## Notes of 2/15 MMC Site Plan Review Meeting (CMP/Detours)

### **Congress Street Closure and associated detours/emergency access (based on the revised docs and plans attached to this e-mail from Gorrill-Palmer)**

**CMP - East Tower and Visitor Garage (based on revised CMP as attached from Turners)**

**MMC HOSPITAL EXPANSION  
 EAST TOWER OVERBUILD  
 STRUCTURAL STEEL  
 TRUCK ROUTE FROM I-295N TO MMC SITE ON  
 WESCOTT STREET  
 1-295 N TO WASHINGTON AVE. TO CONGRESS  
 STREET TO ELLSWORTH STREET TO  
 WESCOTT STREET SITE**

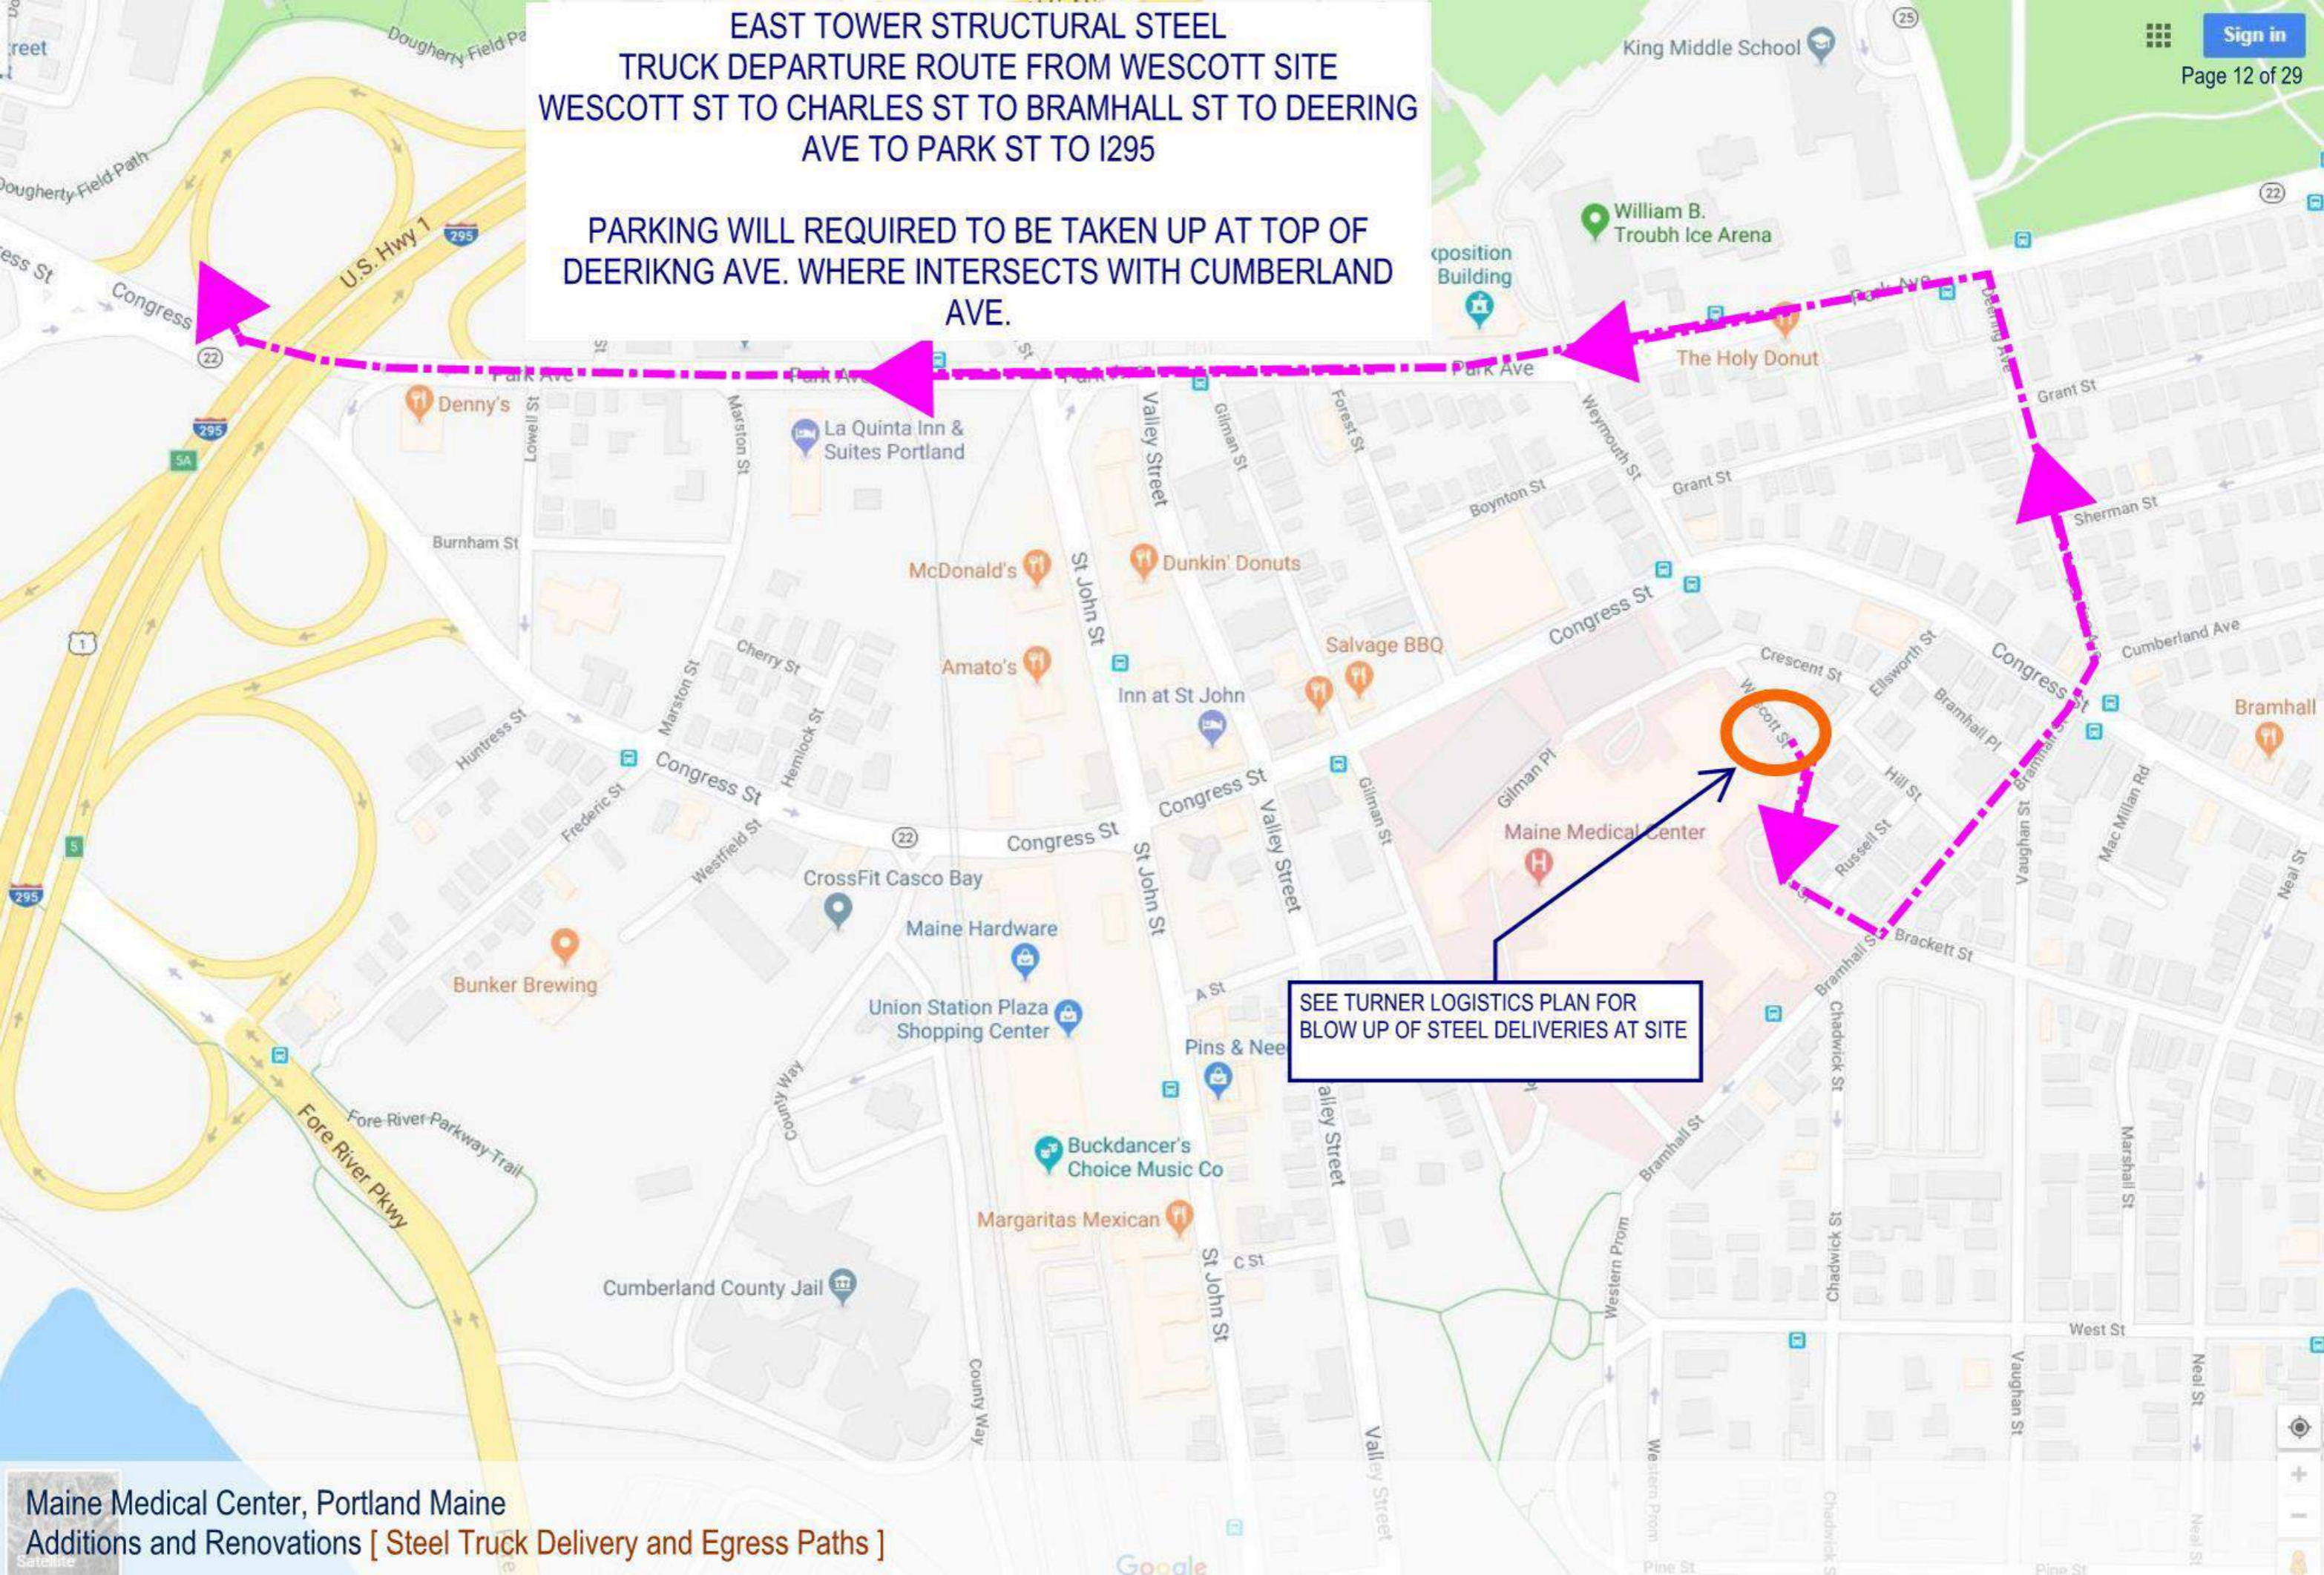
- Reviewers questioned the proposal to route steel deliveries (from North, June 4 to June 28, starting at 5am) along Washington Ave and Congress
  - City staff advised route should avoid Washington completely due to planned construction work

- Route must avoid downtown Portland and Congress
  - Keep delivery vehicles on I295 longer - maybe I295 to Forest /Park ? Deering; maybe Fore River Parkway

- Turners will speak to the trucking company again and get back to us
- Police stressed need for ongoing monitoring and process for making changes to delivery and detour routes after closure starts

1) Congress Street has to be closed for a period of 8 weeks. )

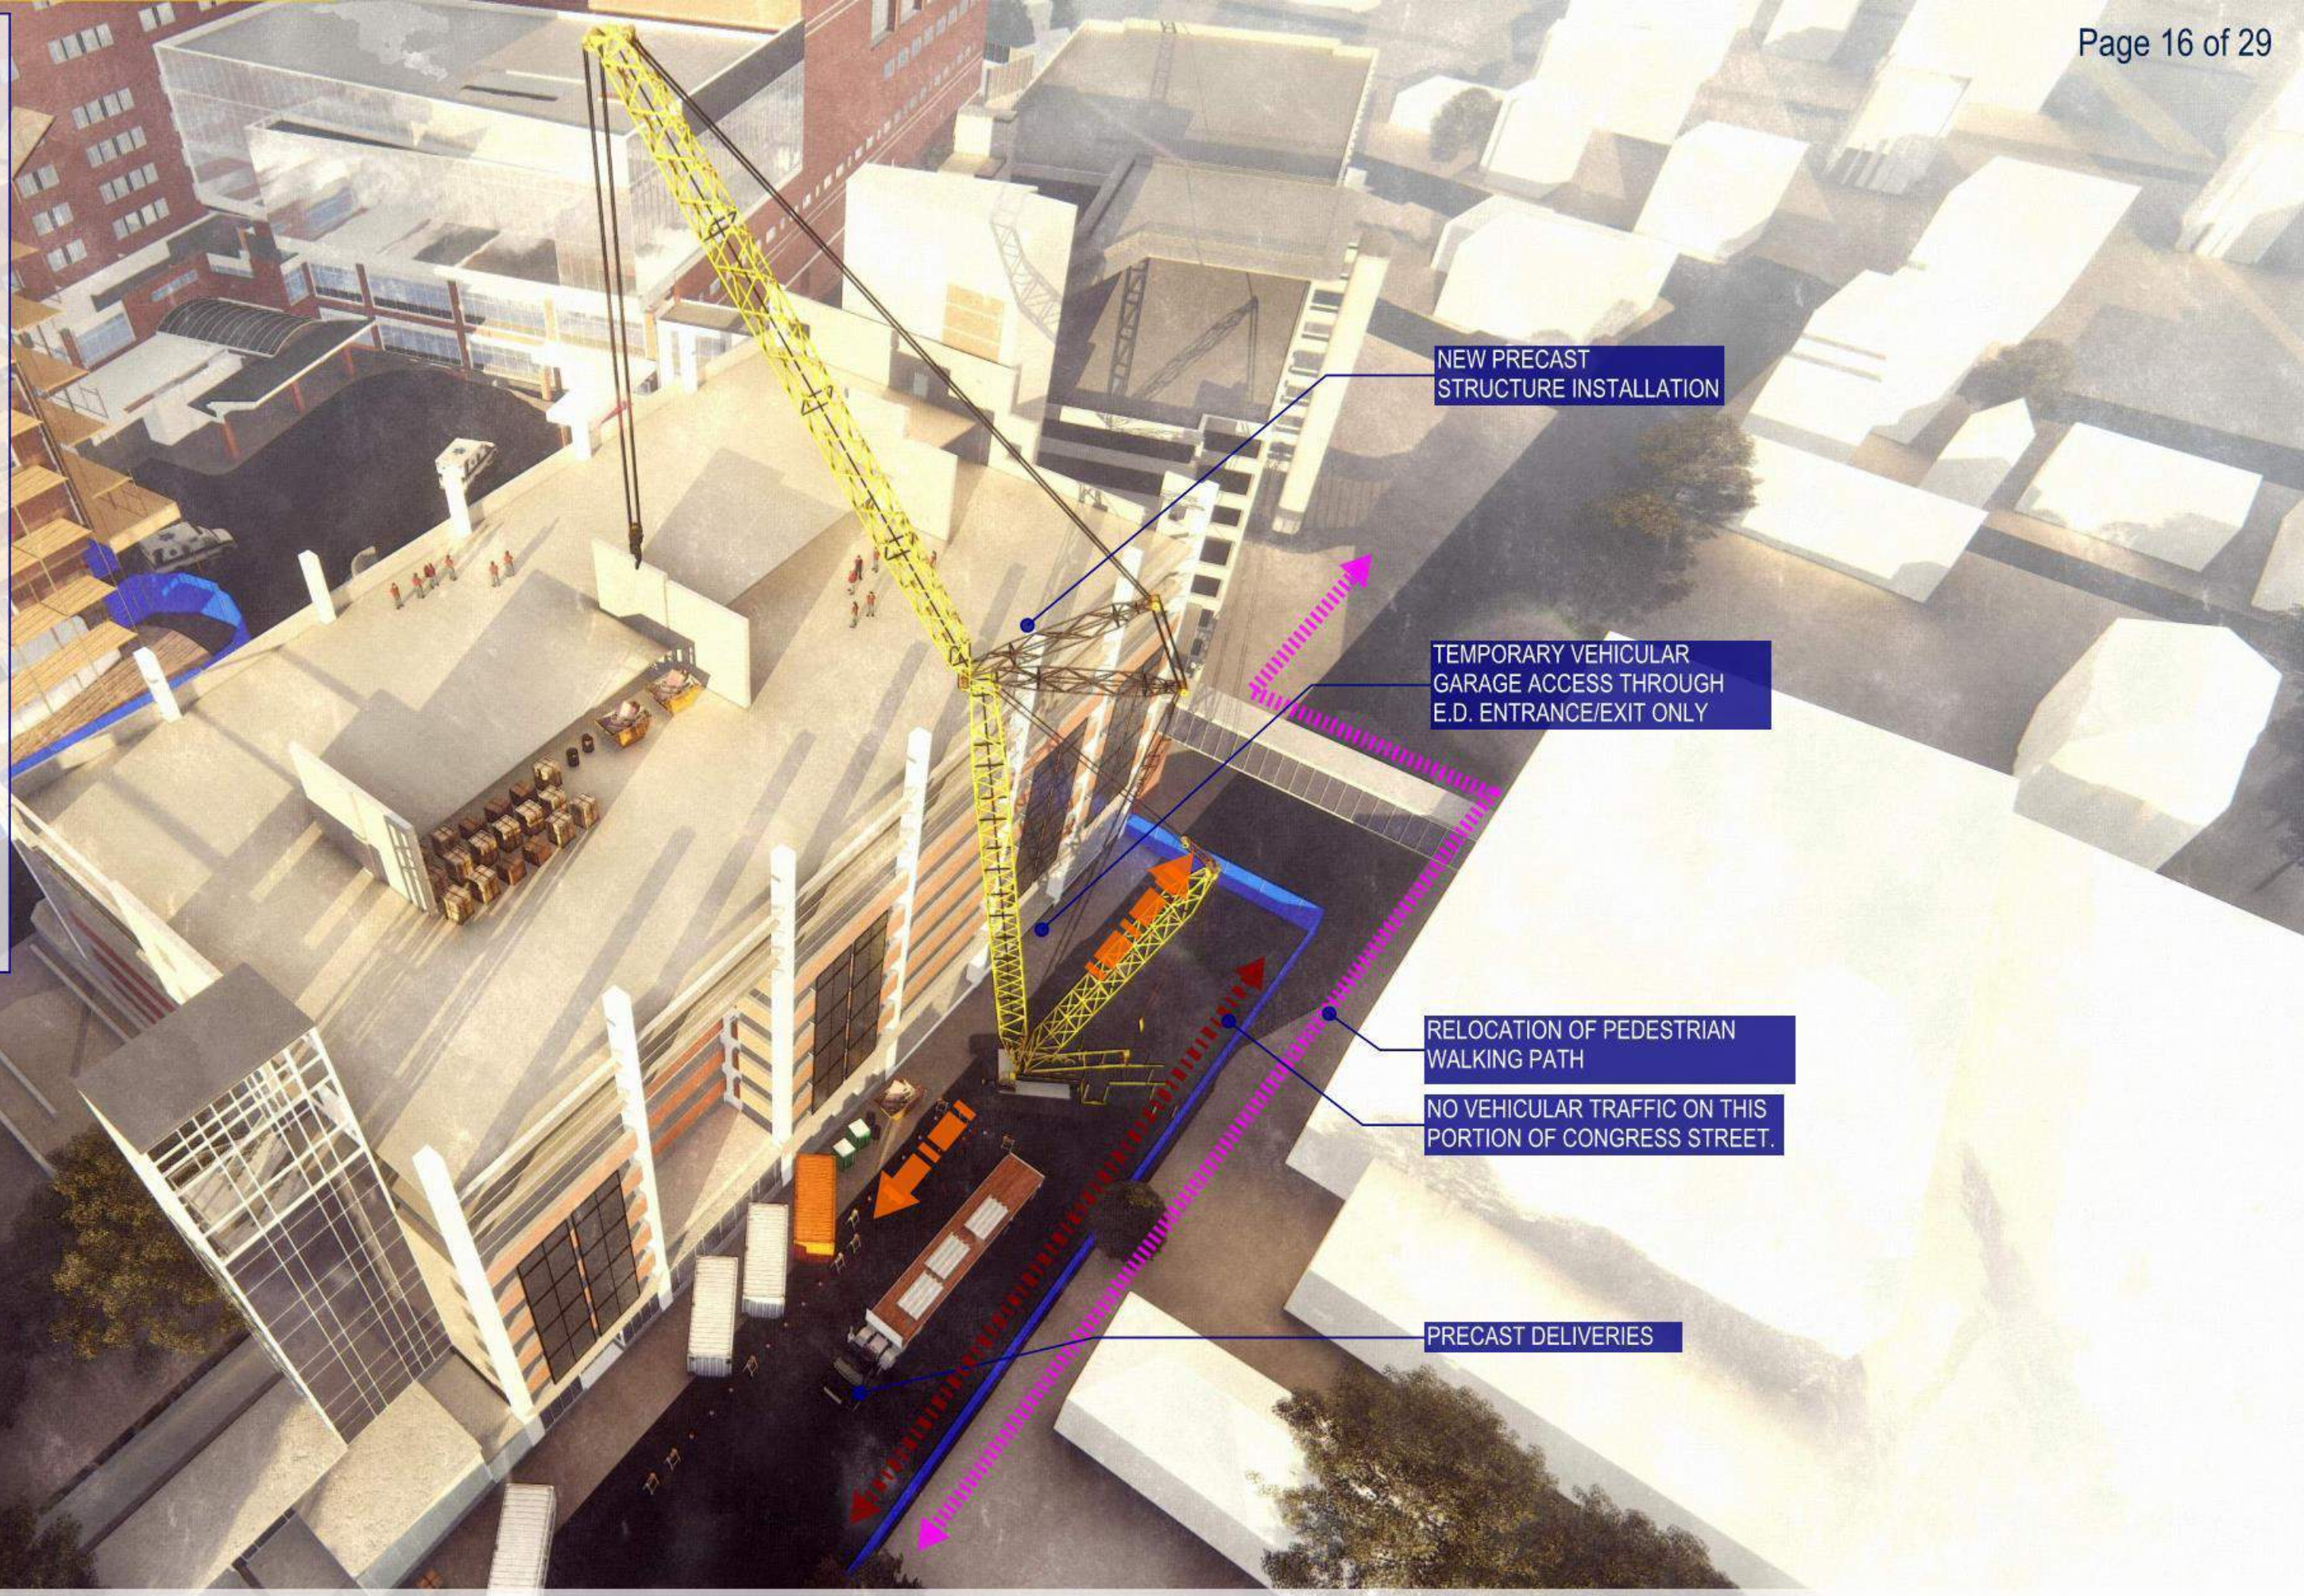
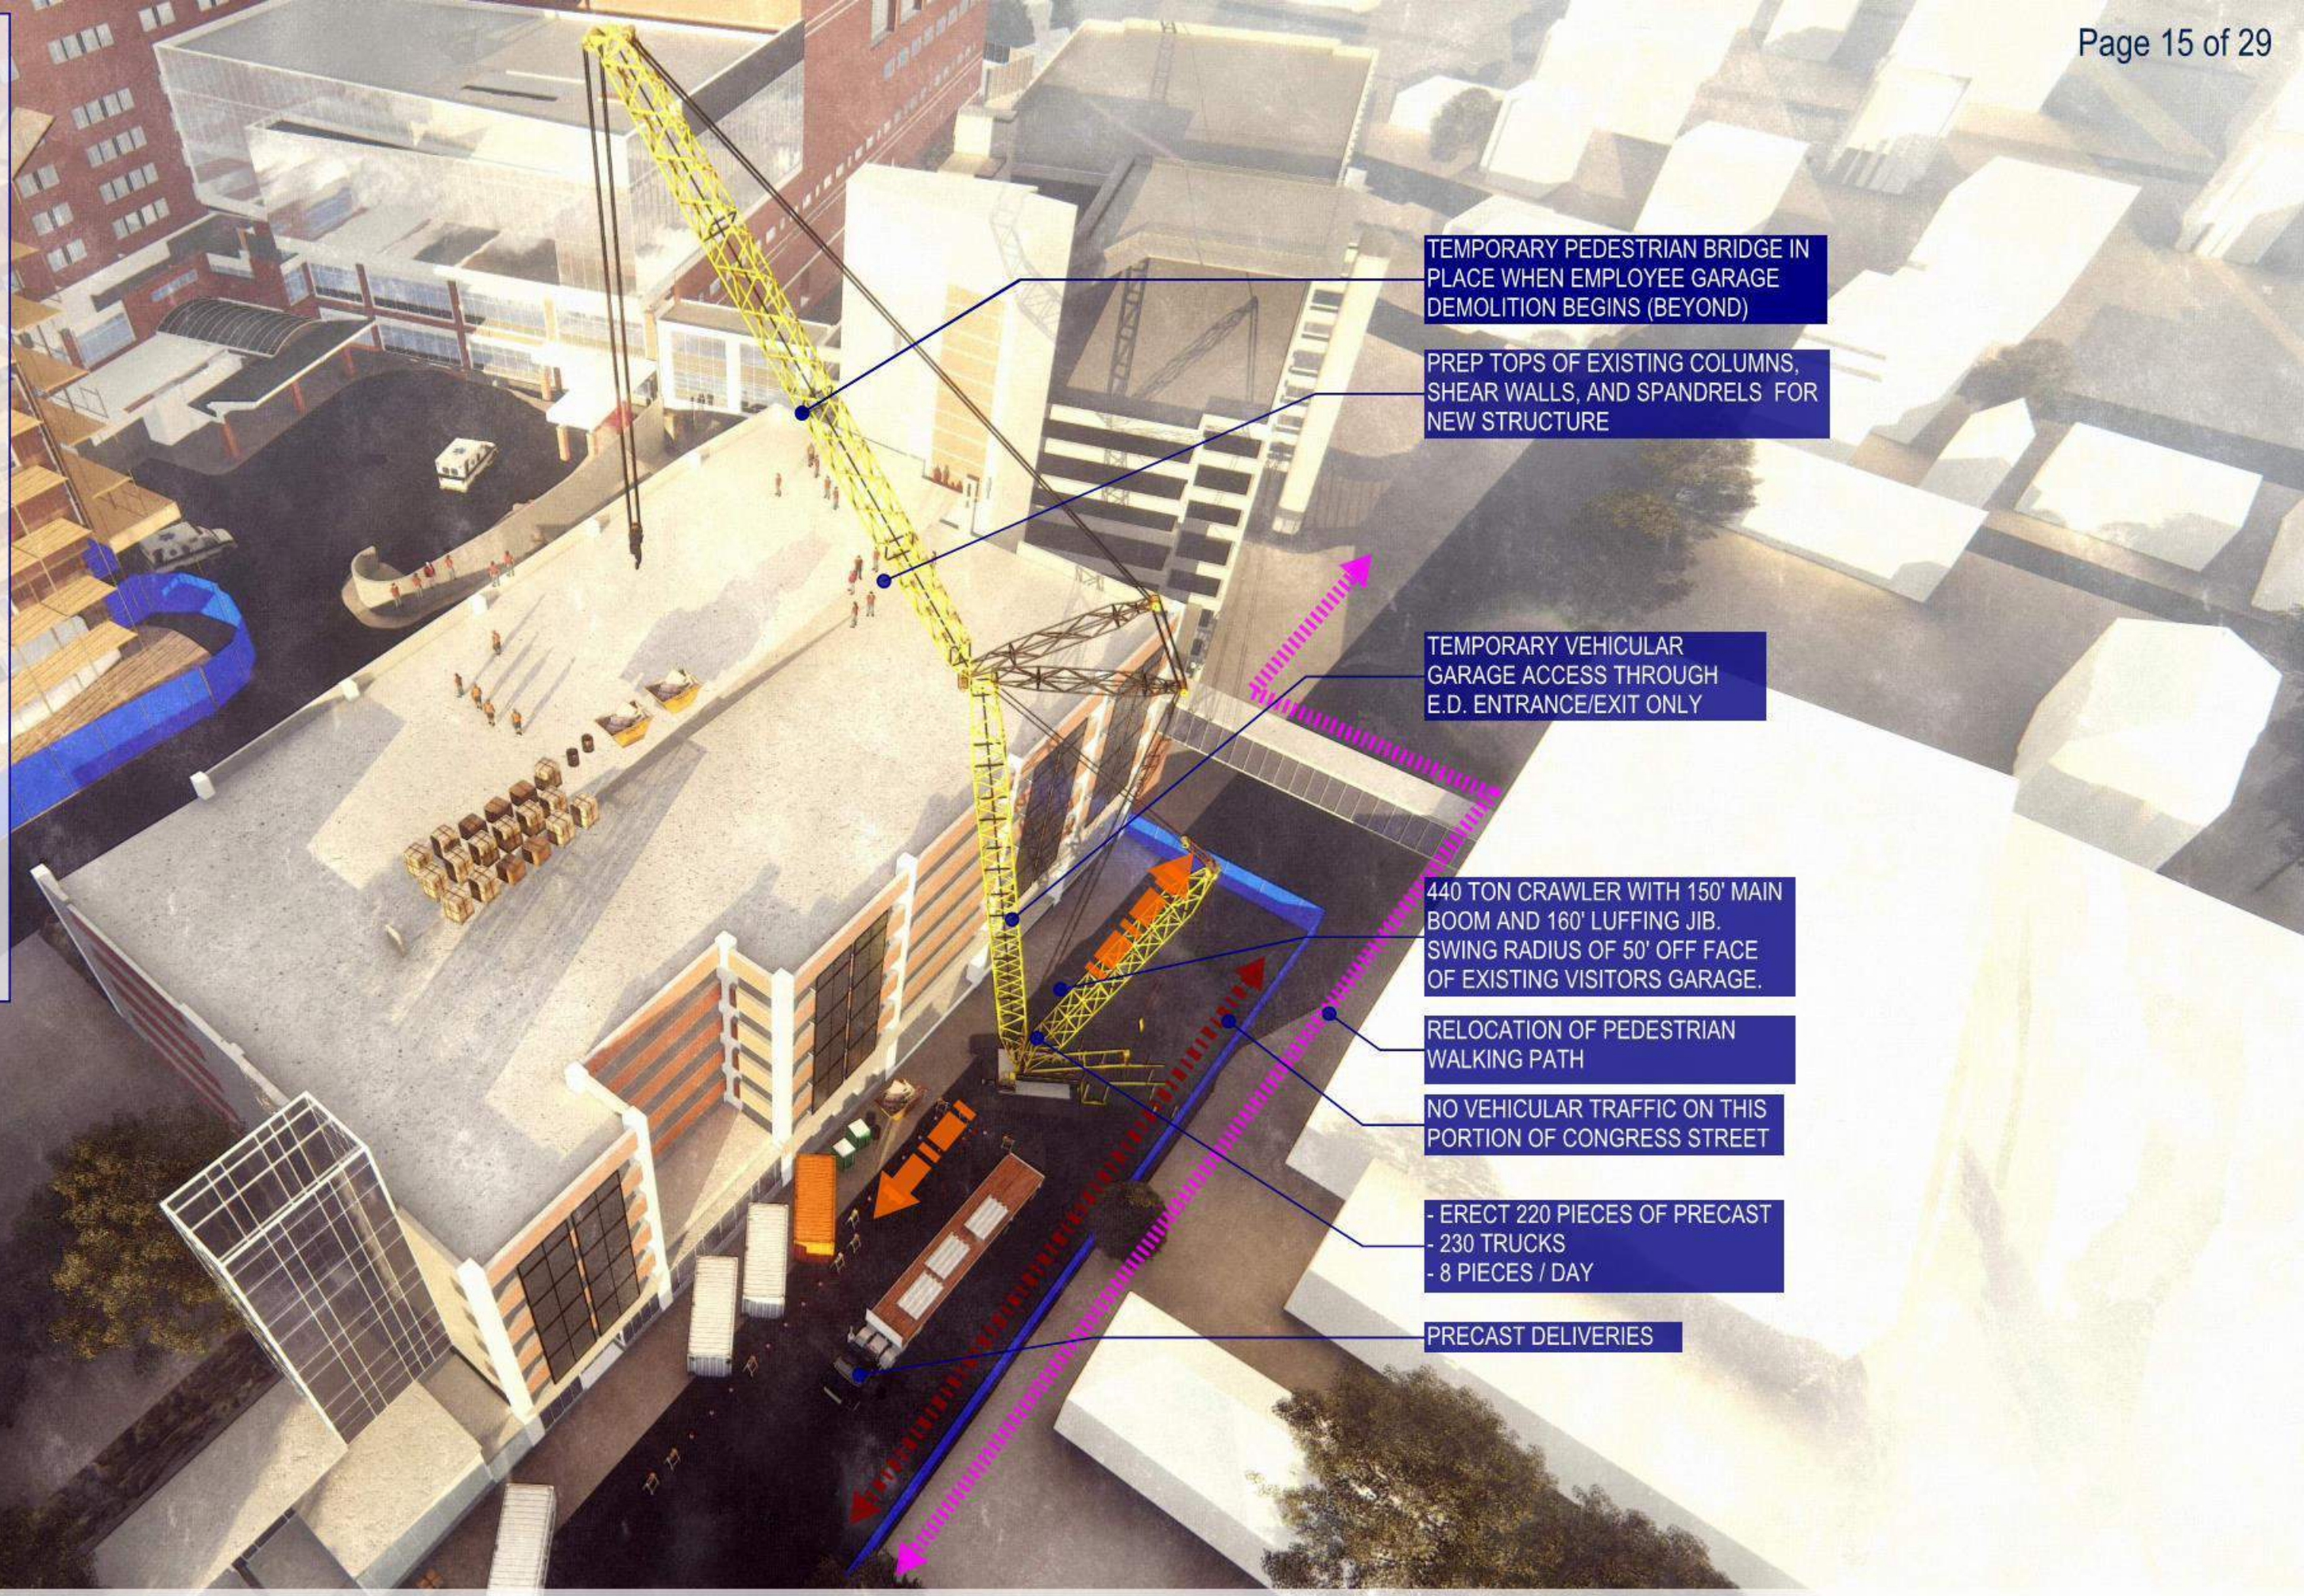
- Concern re pedestrian route along Congress by construction area
  - Need ADA ramp
  - Need 9ft for crossing
  - Ensure entire sidewalk available

- Look at conflicts for peds crossing Weymouth at Congress - need to address
  - Gilman crosswalk needs to be ADA compliant
- Timetable (based on SO (Tuck) discussions with MMC and City Communication Directors)
  - - Need for early completion of telephone tree communication structure/contacts to be circulated within about 2 weeks and to be tested ahead by local and regional responders
  - - In week after 2/27 PB meeting need schedule that includes lead time and actions
  - - Early prep of handouts for employees and visitors plus early website info important
